Athlone Link Road

Site Specific Flood Risk Assessment
262119-PUNCH-XX-XX-RP-C-0001

PUNCH Consulting Engineers was appointed to carry out a Site-Specific Flood Risk Assessment (SSFRA) for the site of a new link road and bus parking area adjacent to Southern Station Road, in Athlone, County Westmeath. This SSFRA report has been prepared in response to Item 1 of a Request for Further Information (RFI) prepared by An Coimisiún Pleanála (ACP) for Case No. ACP-322958-25, dated 5th January 2026.

DRAWING No: 120278-501

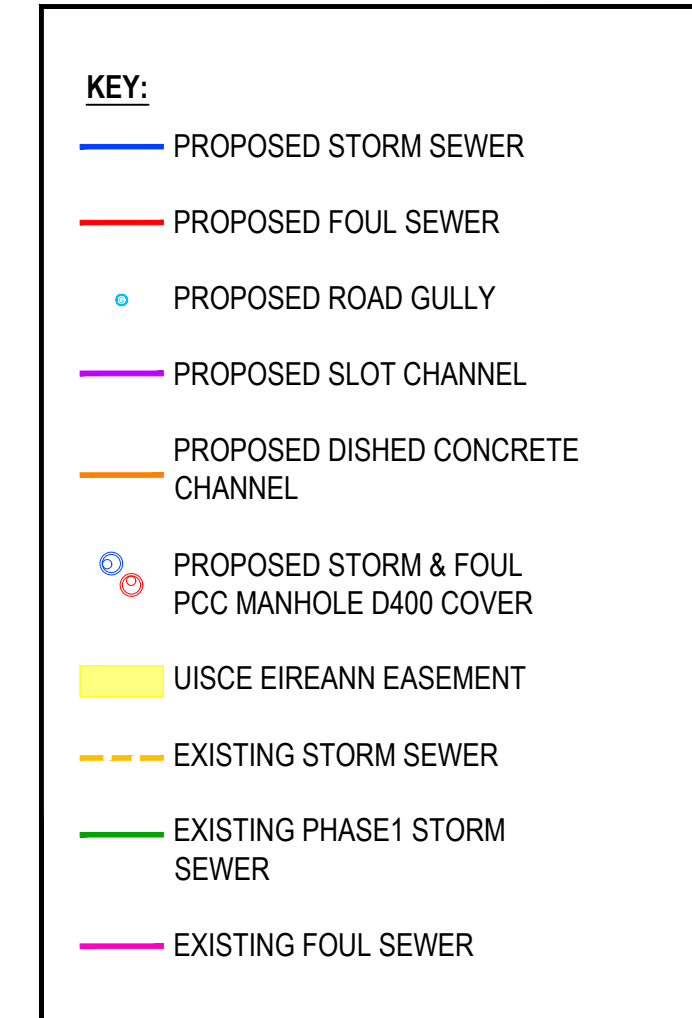
Item 1 of the RFI prepared by ACP and reference in Section 1.1, expresses a concern that *“during exceptional events ... water levels may overtop the discharge control (hydrobrake) and result in short-term uncontrolled flows towards the culvert draining west under Southern Station Road, towards an area that is noted to be prone to flooding under the Shannon Catchment Flood Risk Assessment and Management Study.”*

The proposed storm water drainage system has been revised to accommodate rainfall run-from events up to and including 1 in 100 year return period. A hydrobrake will be installed at the outfall to limit flow to the Q_{bar} greenfield runoff rate, representing the mean annual peak flow from the undeveloped site.

Response: The proposed storm water drainage system will now cater for storm events up to and including the 1 in 100 year (plus climate change). The proposed hydrobrake will limit outflow from the storm network to the Qbar greenfield runoff rate which will reduce the peak runoff rate entering the culvert for all storm events exceeding Qbar and will therefore not exacerbate any downstream flood risk.
